Subject: Conexus Phase 2-3 Sketch Plan (SKP-2020-541)

The Community Services Department has reviewed the development application for CoNexus Phase 2-3 Sketch Plan and has the following comments of behalf of El Paso County Parks. These comments are being provided with acknowledgement of the Memorandum of Understanding (MOU) between El Paso County and Phoenix Bell, L.T.D. which permits up to six crossings of the New Santa Fe Regional Trail. As outlined in the MOU, any potential trail crossing shall be reviewed by the County and meet the terms and conditions set therein.

CONEXUS
BUSINESS CENTER
PHASE 2 & 3
SKETCH PD PLAN

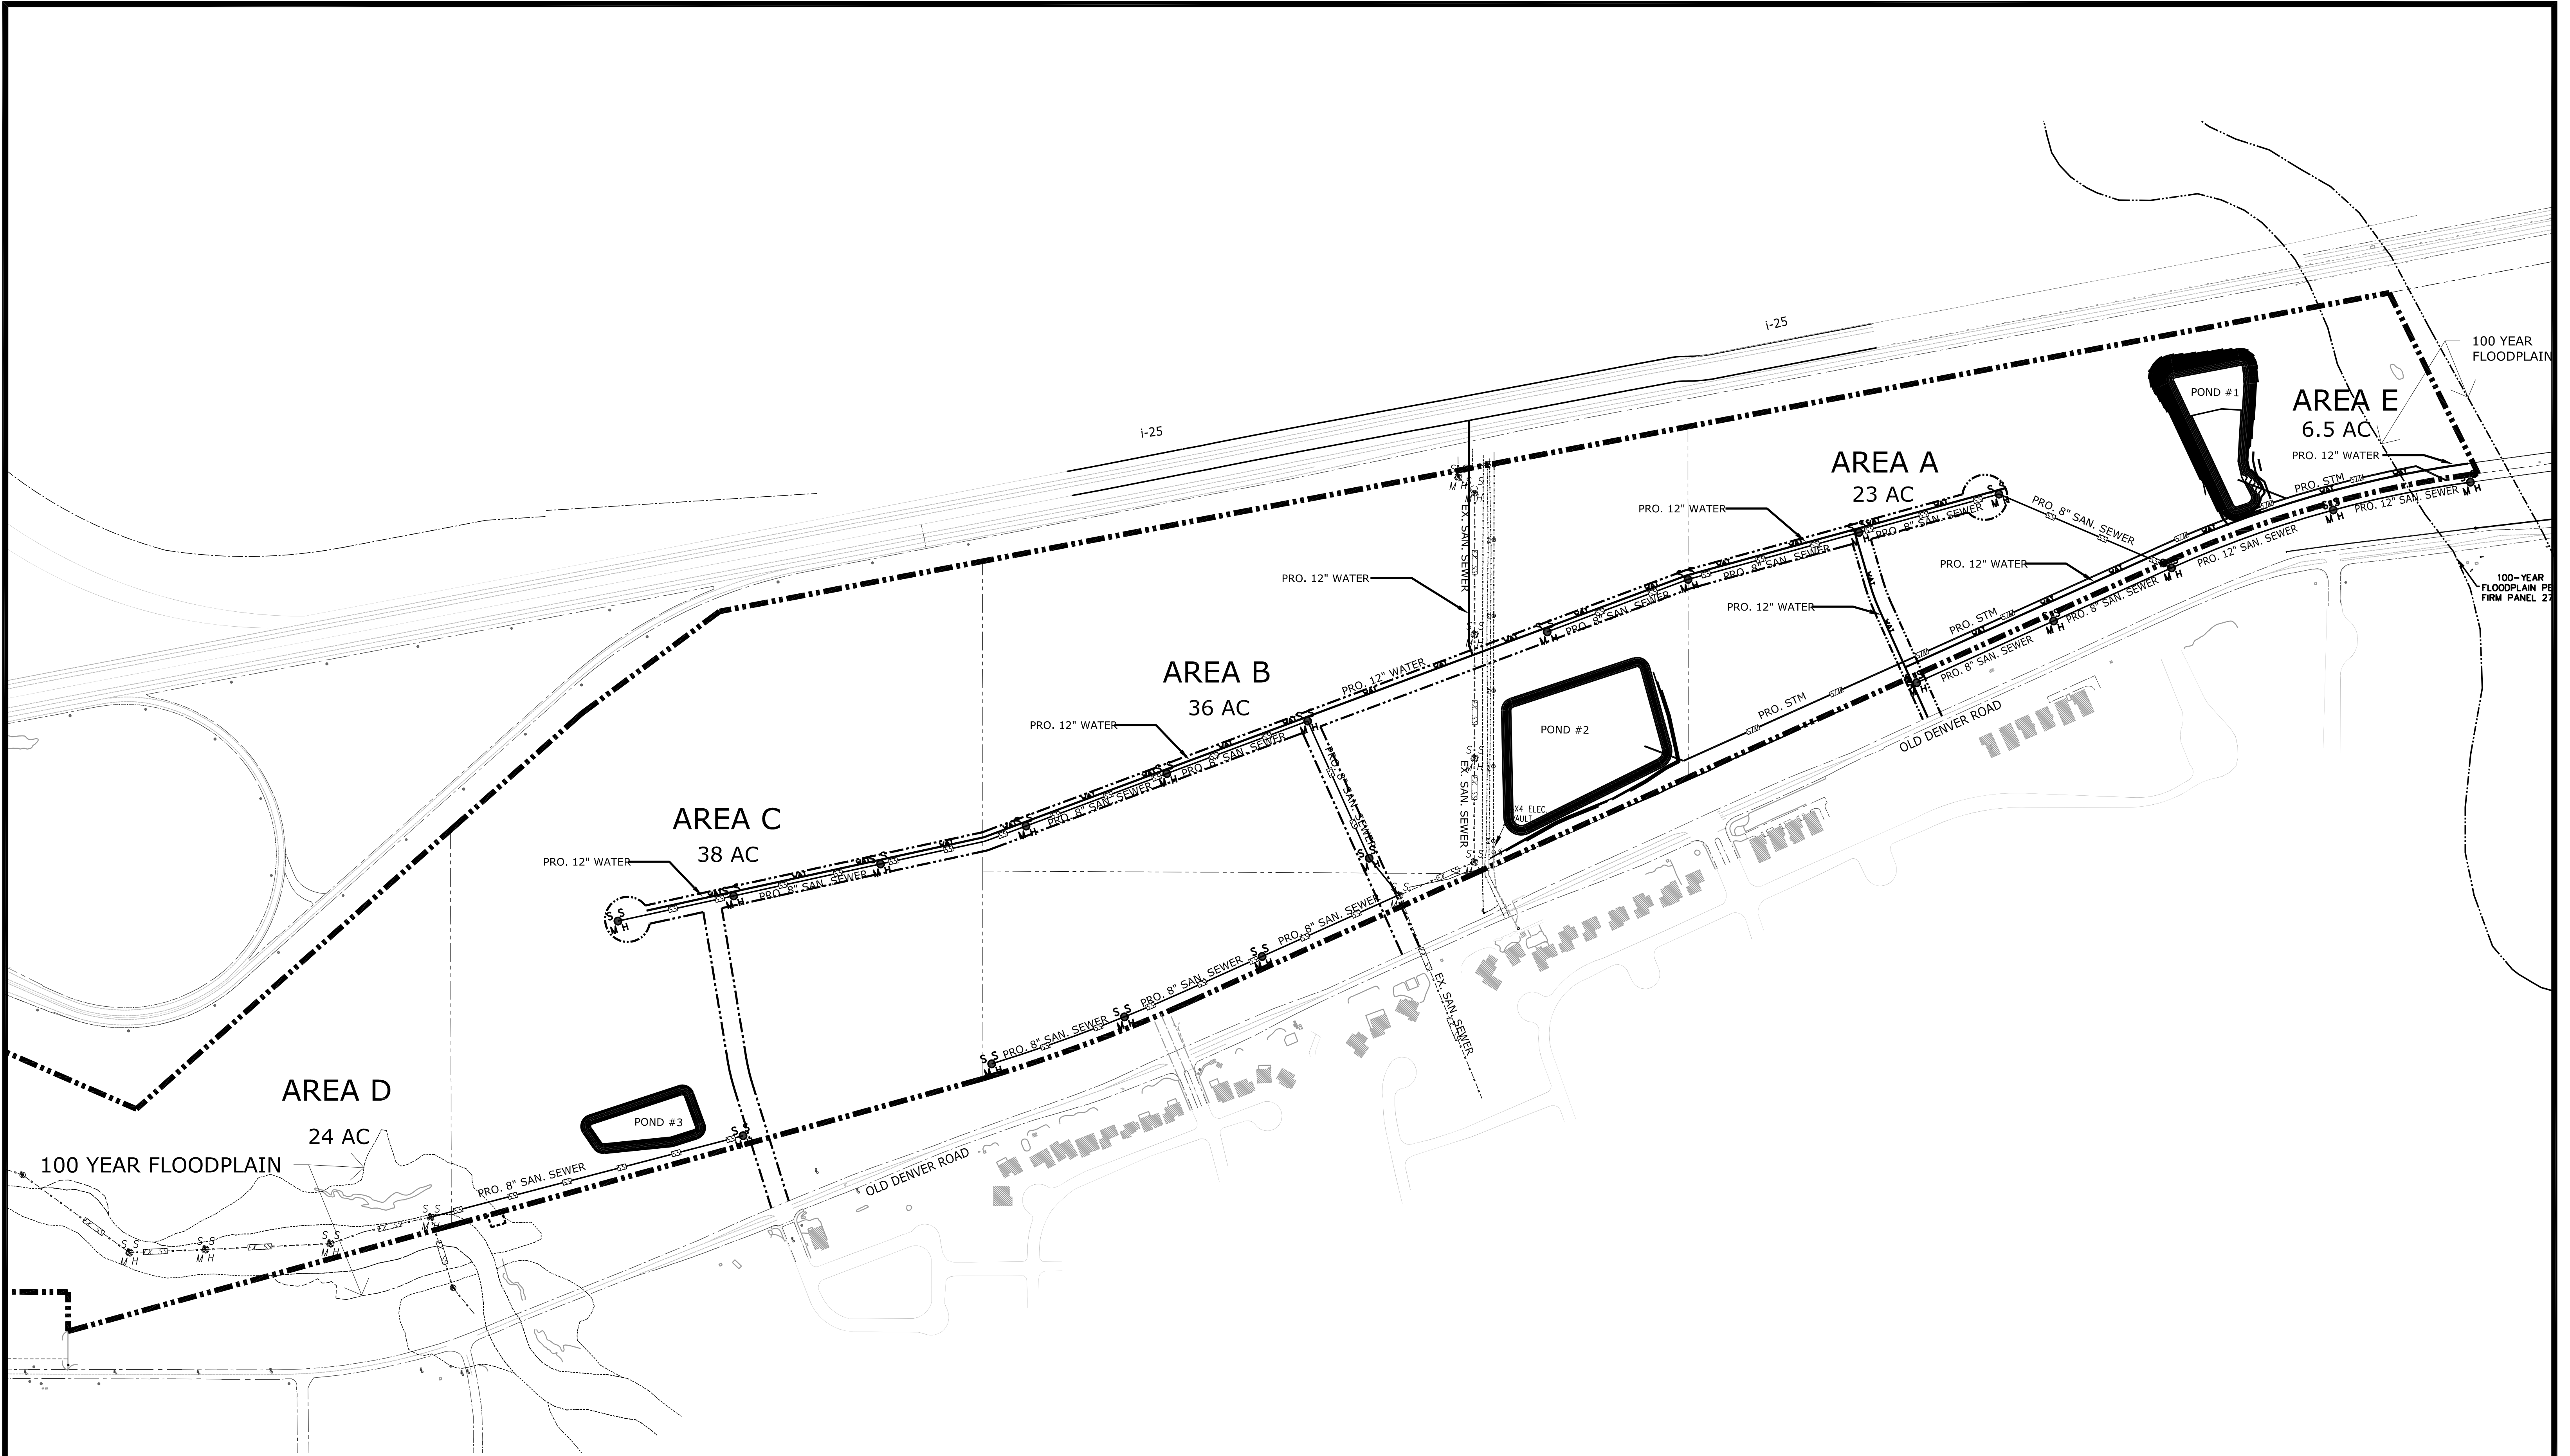
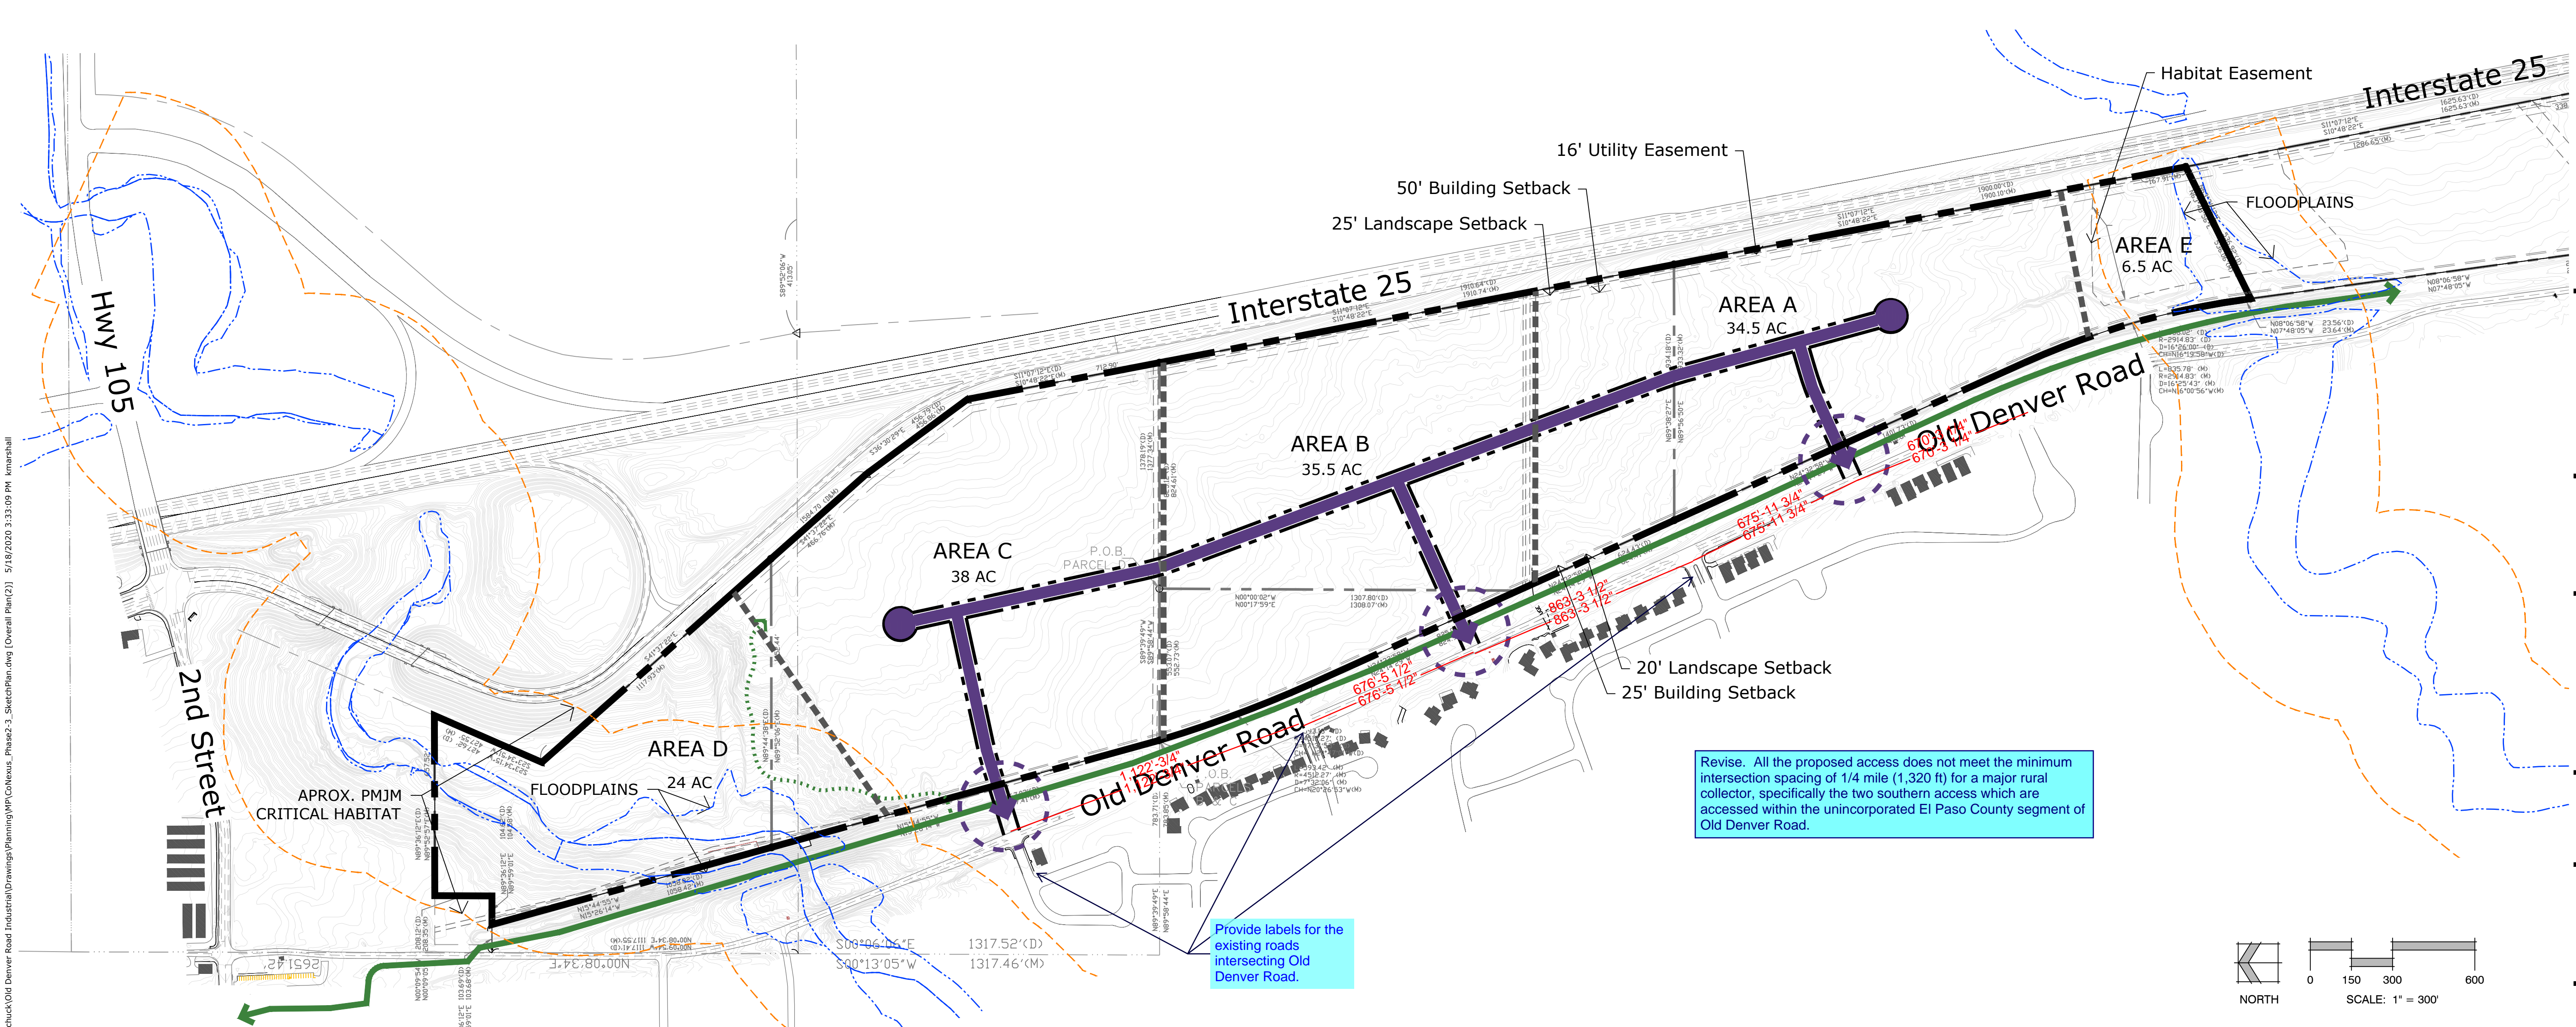
The Sketch Plan drawings show three proposed crossings of the New Santa Fe Regional Trail. There is also a note outlining the specific requirements for the crossings derived from the MOU, which state a license agreement and trail signage plan be provided and approved by the County prior to recording of the first Final Plat. Parks staff appreciates the inclusion of the trail on the drawings and notes.

Parks staff notes open space dedication is primarily located on the northern and southern end of the site. Staff asks the applicant to consider expanding the open space along the trail corridor to provide more buffering and additional screening opportunities to the trail.

It is noted that the Sketch Plan shows a non-County trail through Area D. Parks staff is seeking clarification on whether this is a dead-end trail, or if there is a connection being made to an internal trail, sidewalk, or Town of Monument Trail. A non-County trail connection from the New Santa Fe Trail to the Conexus site is encouraged and would provide non-motorized access to the site.
